HANNAH RIDGE at FEATHERGRASS FILING NO. 3

A RE-PLAT OF TRACT FF, HANNAH RIDGE AT FEATHERGRASS FILING NO. 1, SECTION 32, TOWNSHIP 13 SOUTH, RANGE 65 WEST of the 6th PRINCIPAL MERIDIAN, EL PASO COUNTY, COLORADO

FINAL PLAT HANNAH RIDGE AT FEATHERGRASS FILING NO. 3	
 MVE, INC. ENGINEERS SURVEYORS 1903 Lelaray Street, Suite 300 Colorado Springs, CO 80909 719.635.5736 www.mvecvl.com	MVE PROJECT: 60970-F3 MVE DRAWING: 60970221-F3 DATE: JULY 25, 2017 SHEET: SHEET 2 OF 3

Markup Summary

SHEET 2 OF 3

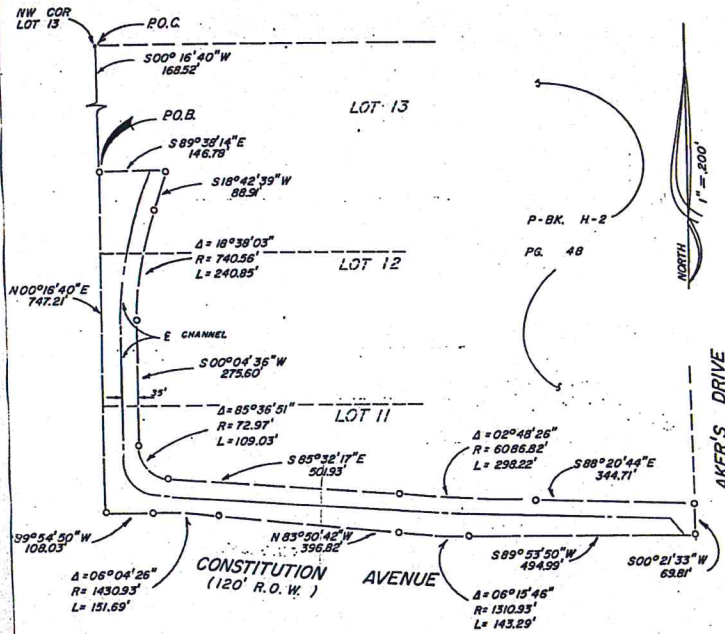
Provide when available

Provide when available
